Requested Revisions for 86 Morning Street Permit Application

Attached please find the updated drawings addressing all of your redlines for the renovation of 86 Morning Street. We now plan to demolish the garage, as it is not salvageable.

DECK FRAMING NOTES:

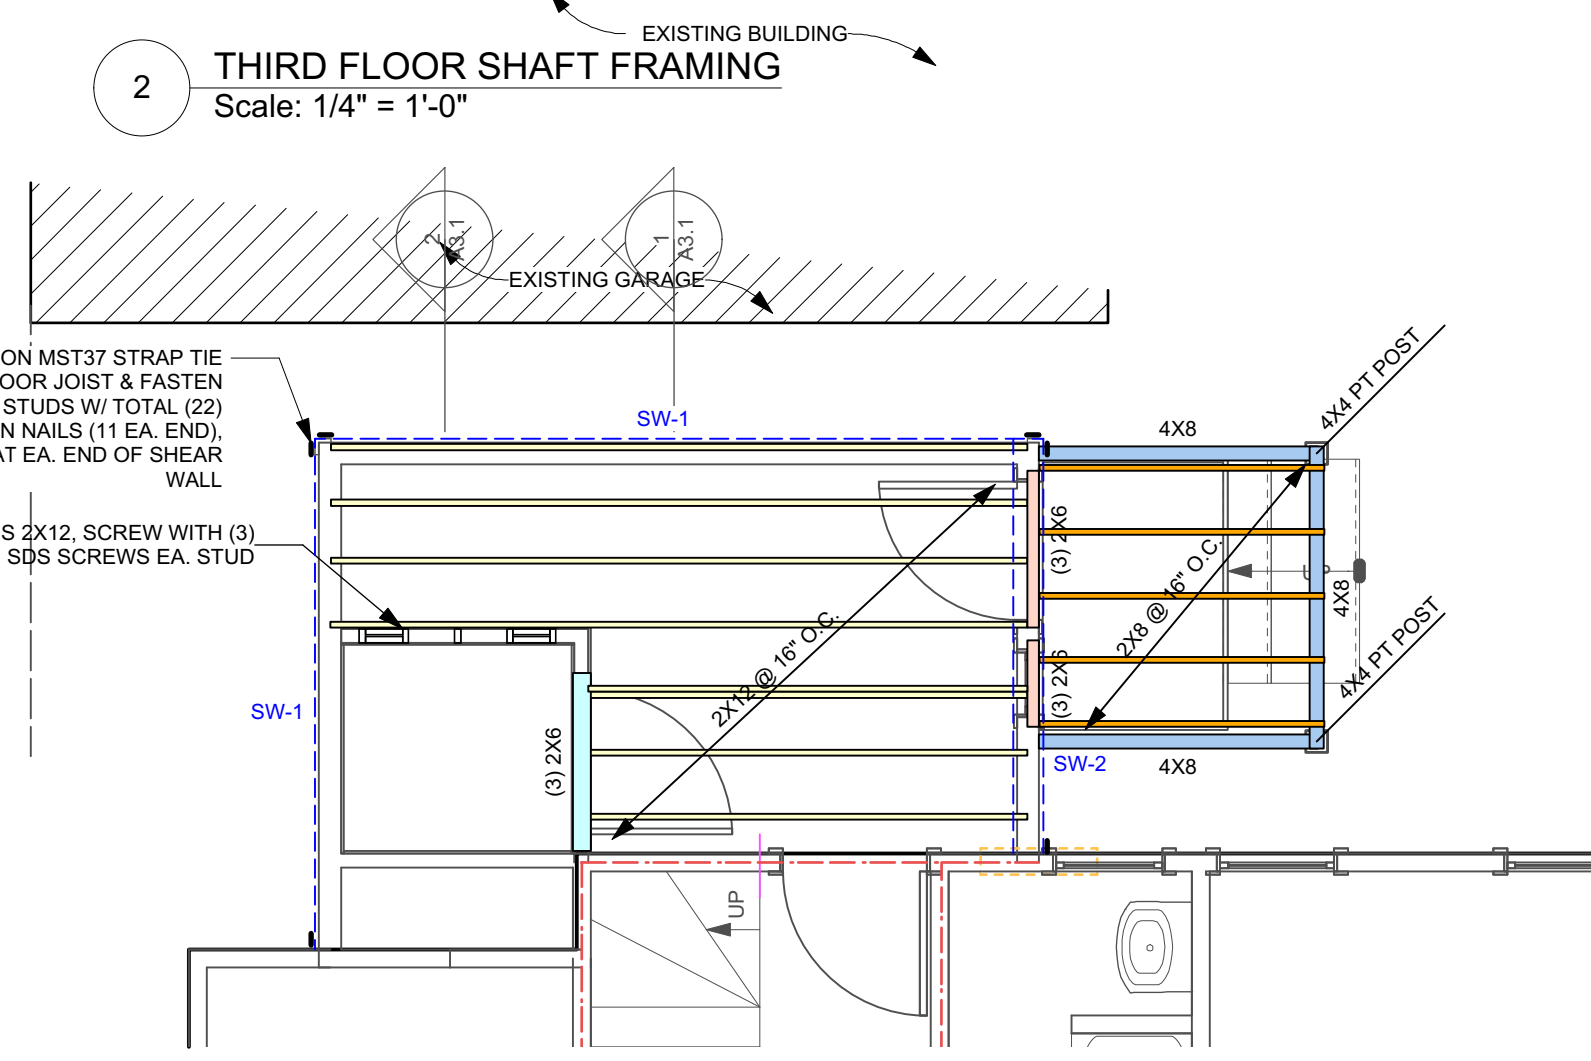
- Post to deck detail added
- Flashing detail at deck to building added
- Added Simpson model number for post caps at deck
- Note explaining that the garage will be demolished under a separate permit, already filed.
